## Planning Consultation Memo

Date	Planning Officer	Environmental Health Officer
31/12/2021	Mr David Elmore	Terry Vincent
Planning Application Number	Worksheet Number	
6/2021/3172/FULL	WK128531

**Address:** 51 Kentish Lane Brookmans Park Hatfield AL9 6NG

**Application Details:** Change of use of site (house and garden) from a dwellinghouse (Use Class C3) to a mixed-use as a dwellinghouse (Use Class C3) and for commercial film-making and photographic activities (Sui-Generis)

Project:	51 Kentish Lane Brookmans Park AL9 6NG	Drawn By:	AEH
Drawing Title:	Site Plan Lighting Exclusion Zone	Date Drawn:	03/02/2021
Scale:	1:500 (A3)	Drawing Number:	TDC058/PL2/001
Rev:	-	Rev:	-

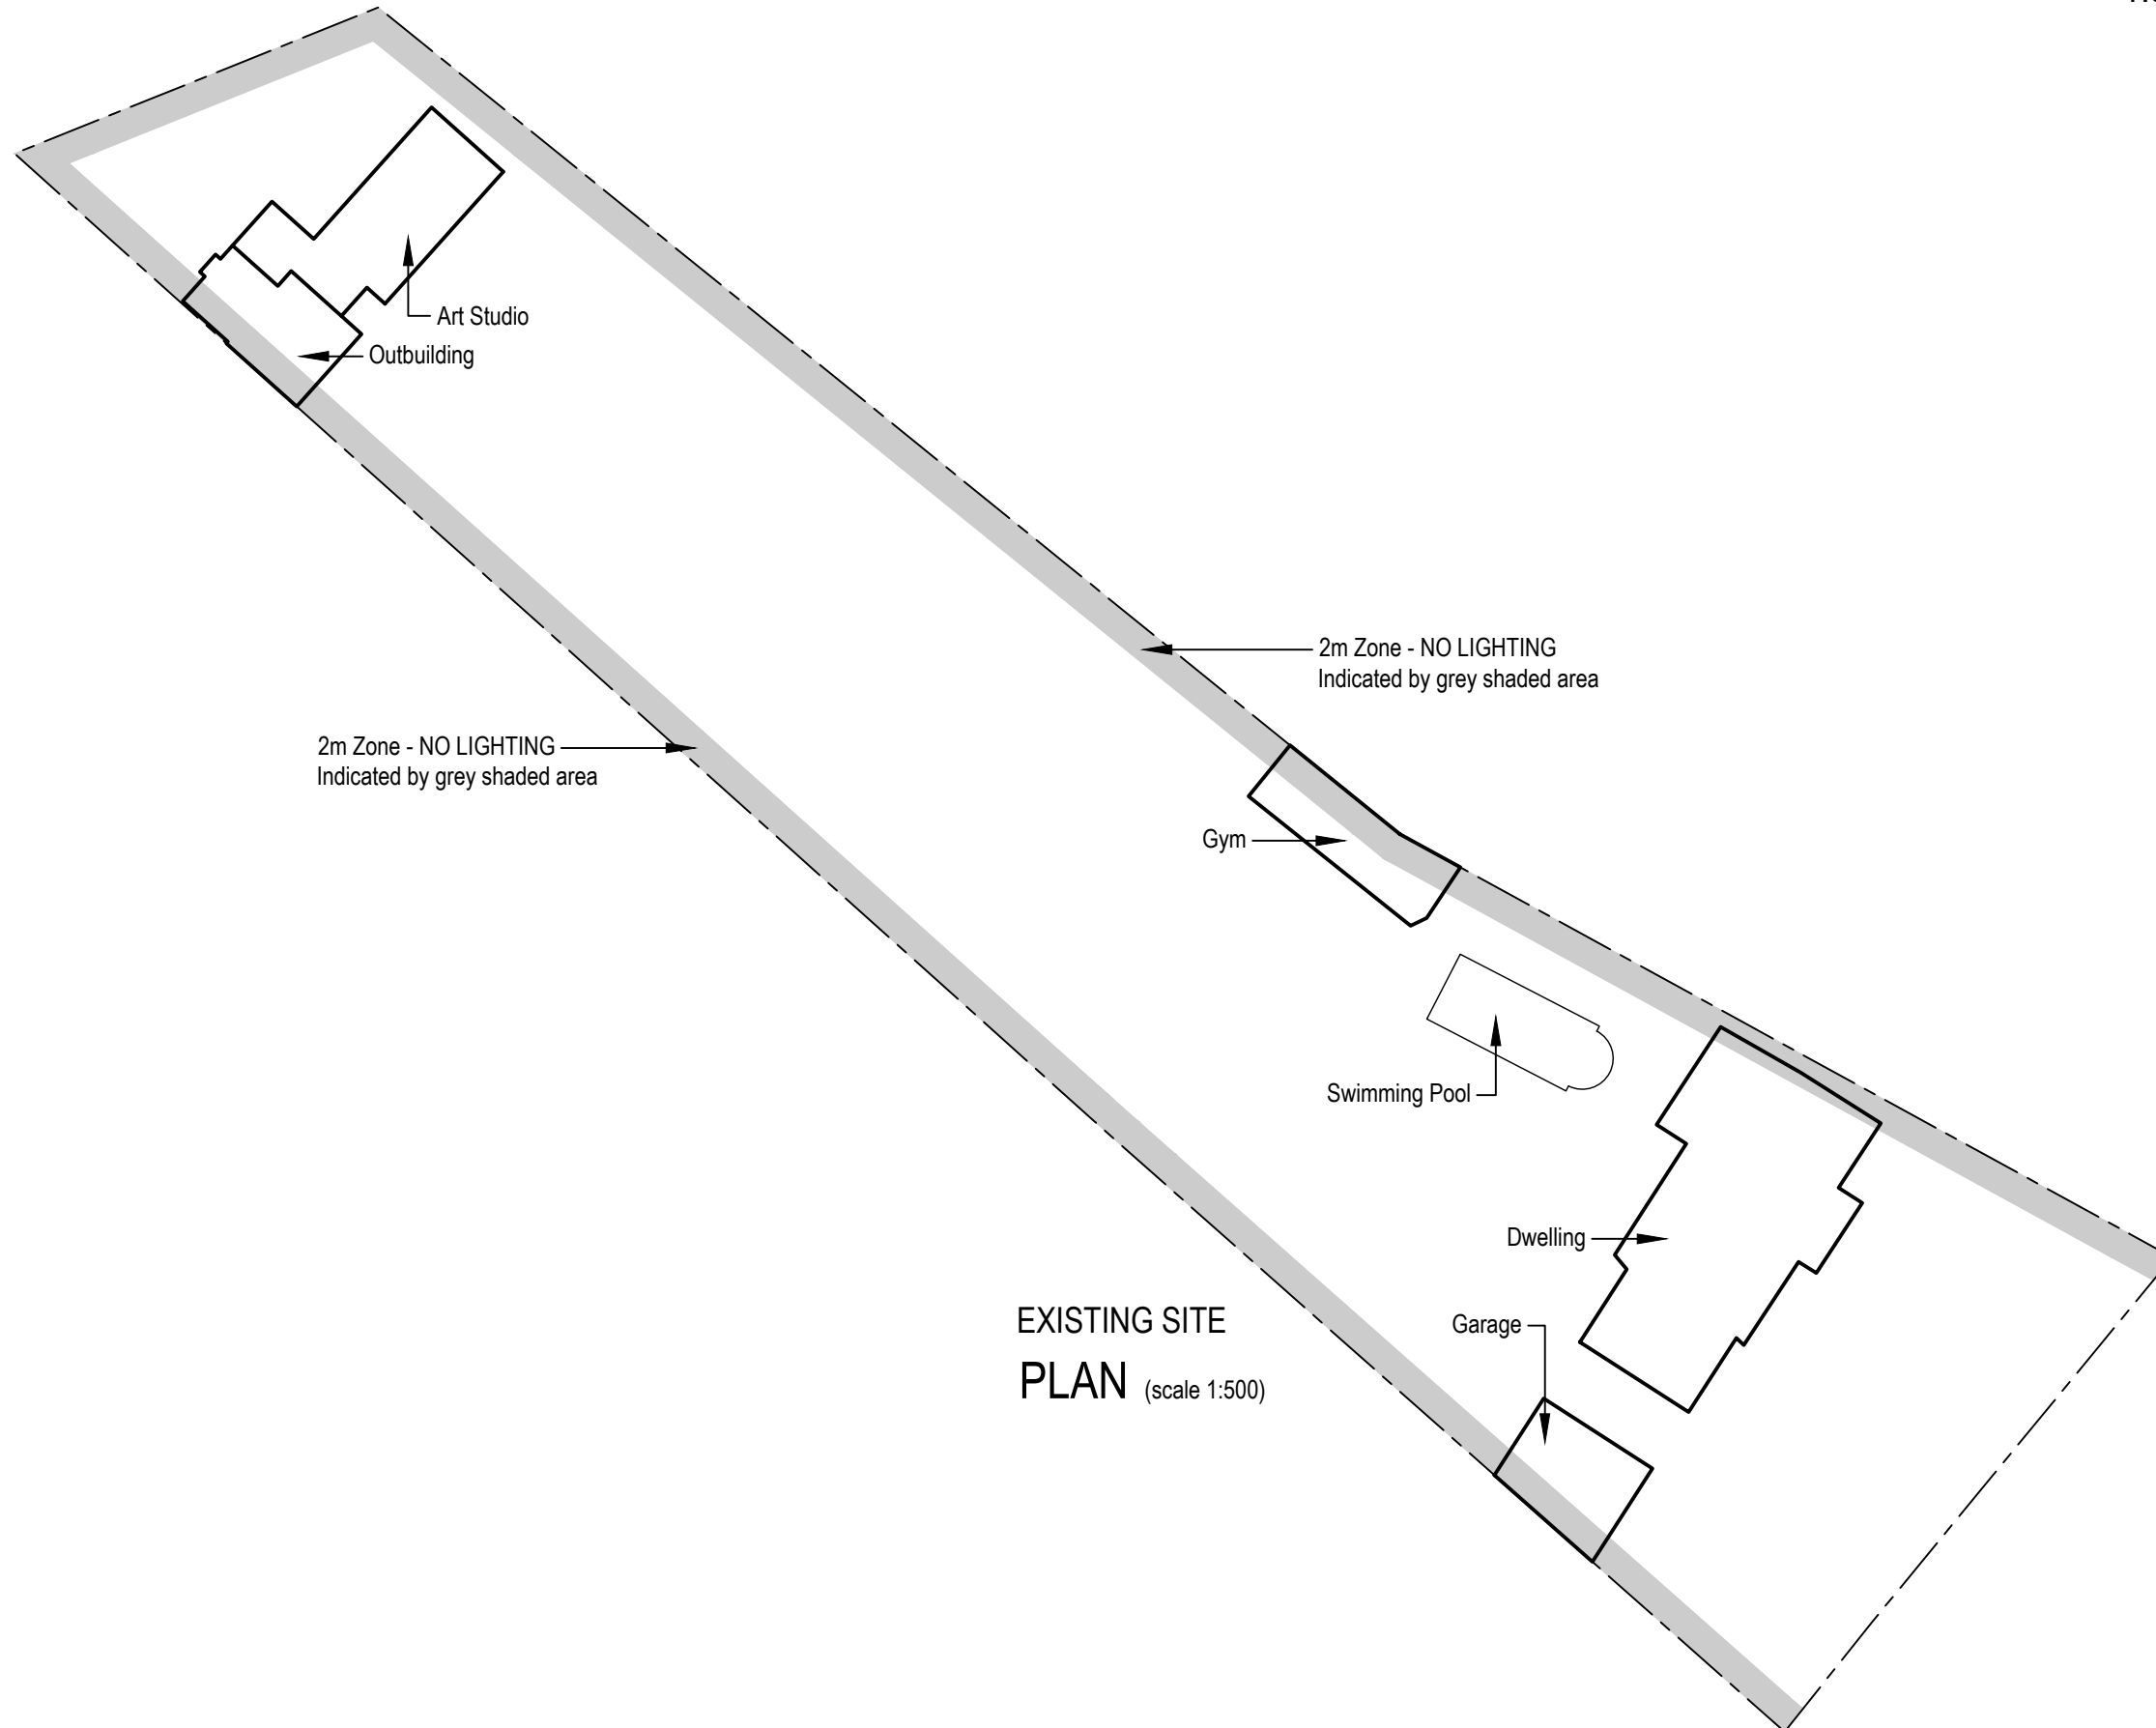
Lighting systems must be used in such a way that light does not shine directly into any neighbouring properties. Care must be taken to prevent light intrusion and to ensure that a statutory nuisance does not occur at neighbouring properties.
